ENG-PUDSP22007-R3-TISpdf.pdf Markup Summary

Subject: Callout
Page Index: 7
Date: 4/4/2023 1:55:57 PM
Author: CDurham
Color: ■
Layer:
Space:
Page Label: 7

Figure 2  
**Site Plan**

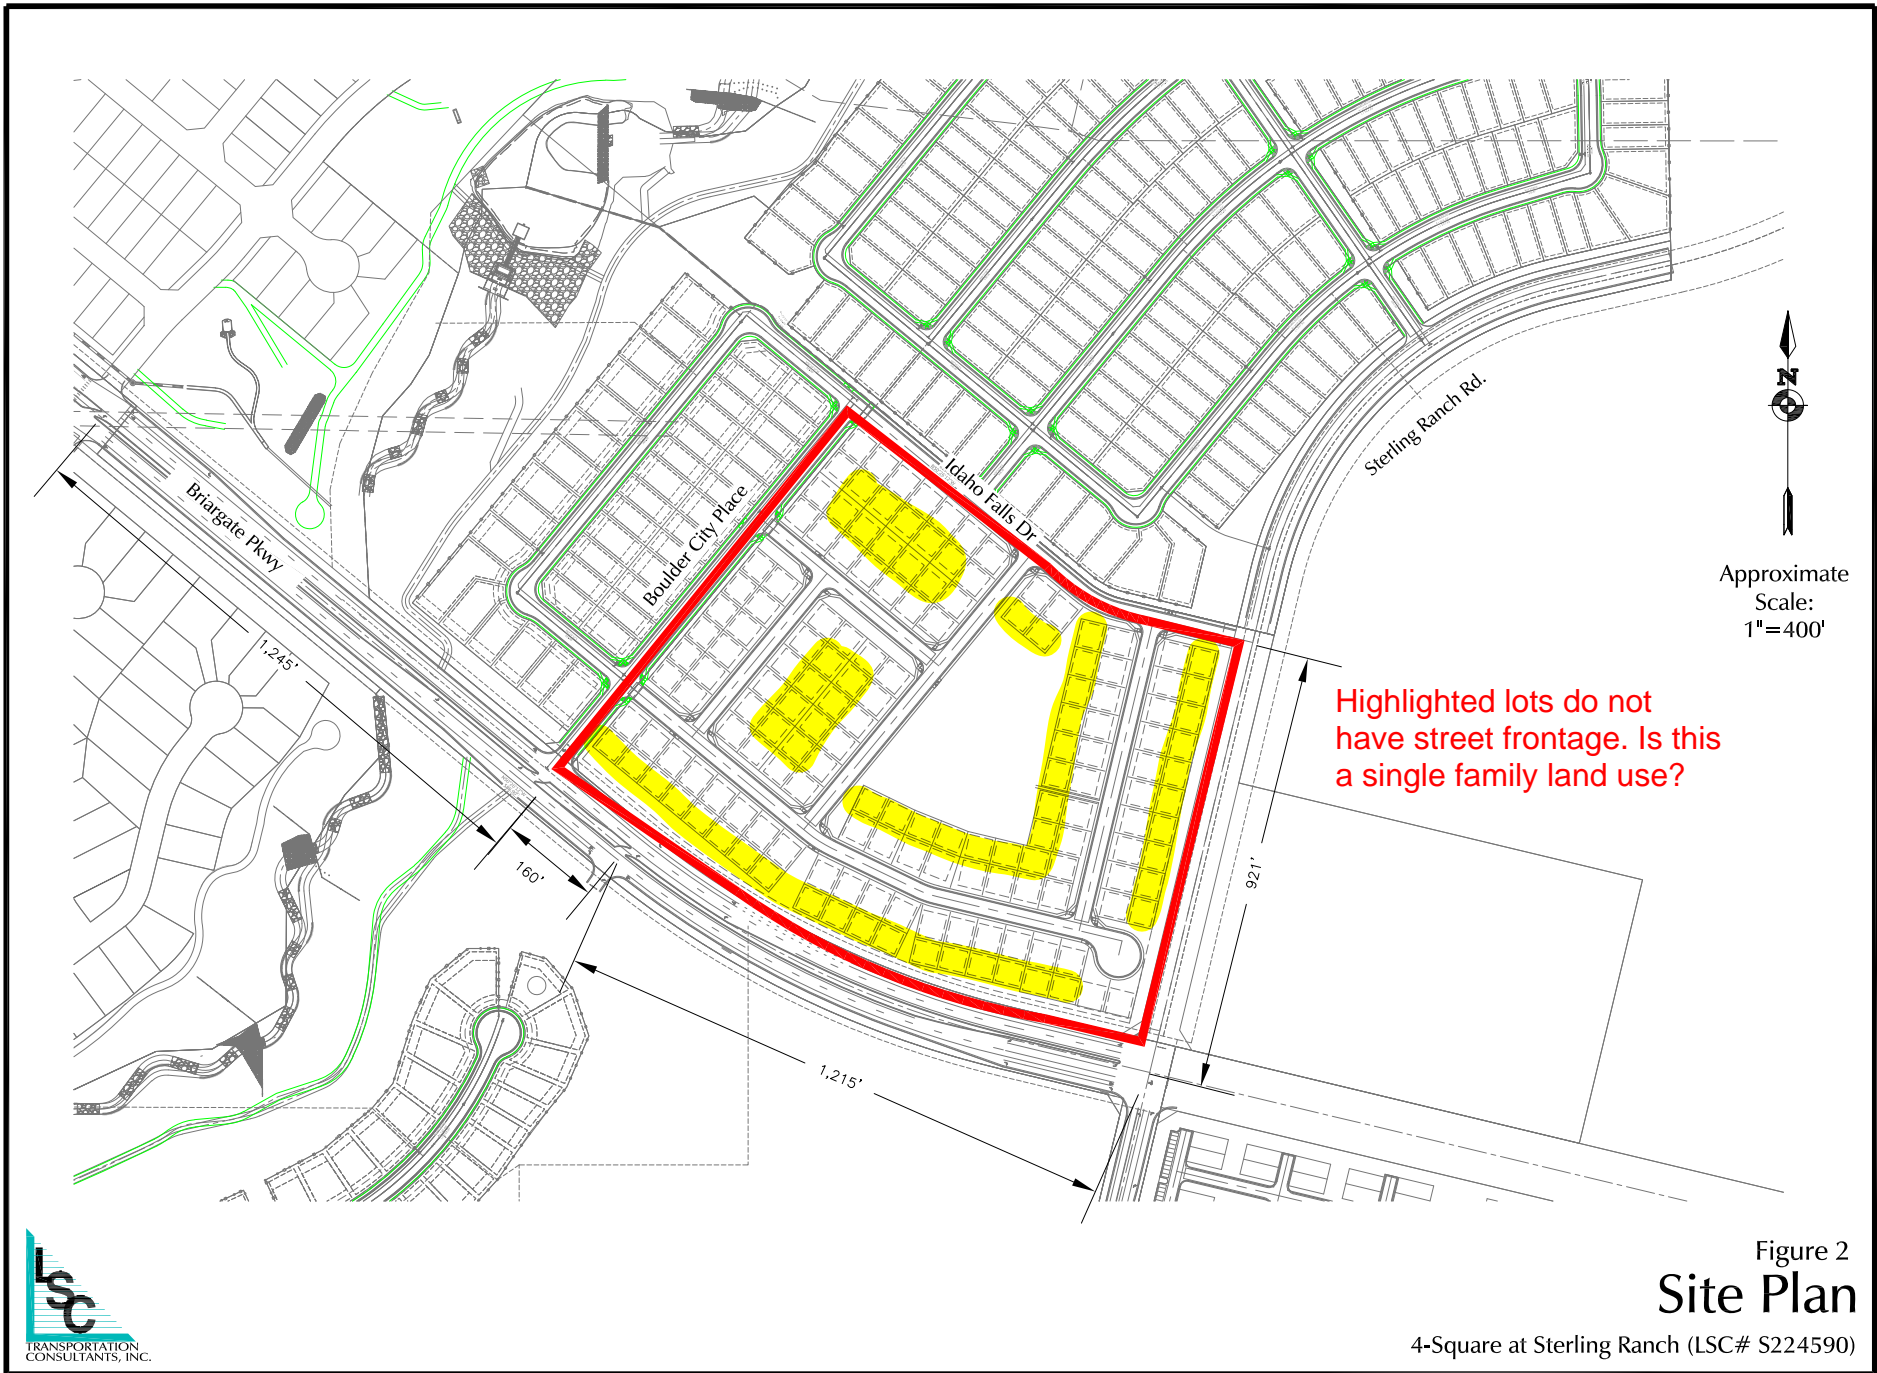
Unresolved: Address recommendations for pedestrian refuge islands where applicable per ECM 2.5.6.G-J. (see redlines on Figure 2)

Unresolved: Address pedestrian refuge / splitter islands at the corners required per ECM, for long-term buildout (including school pedestrian traffic). A midblock crossing is probably not the desired solution when there is an intersection here already.
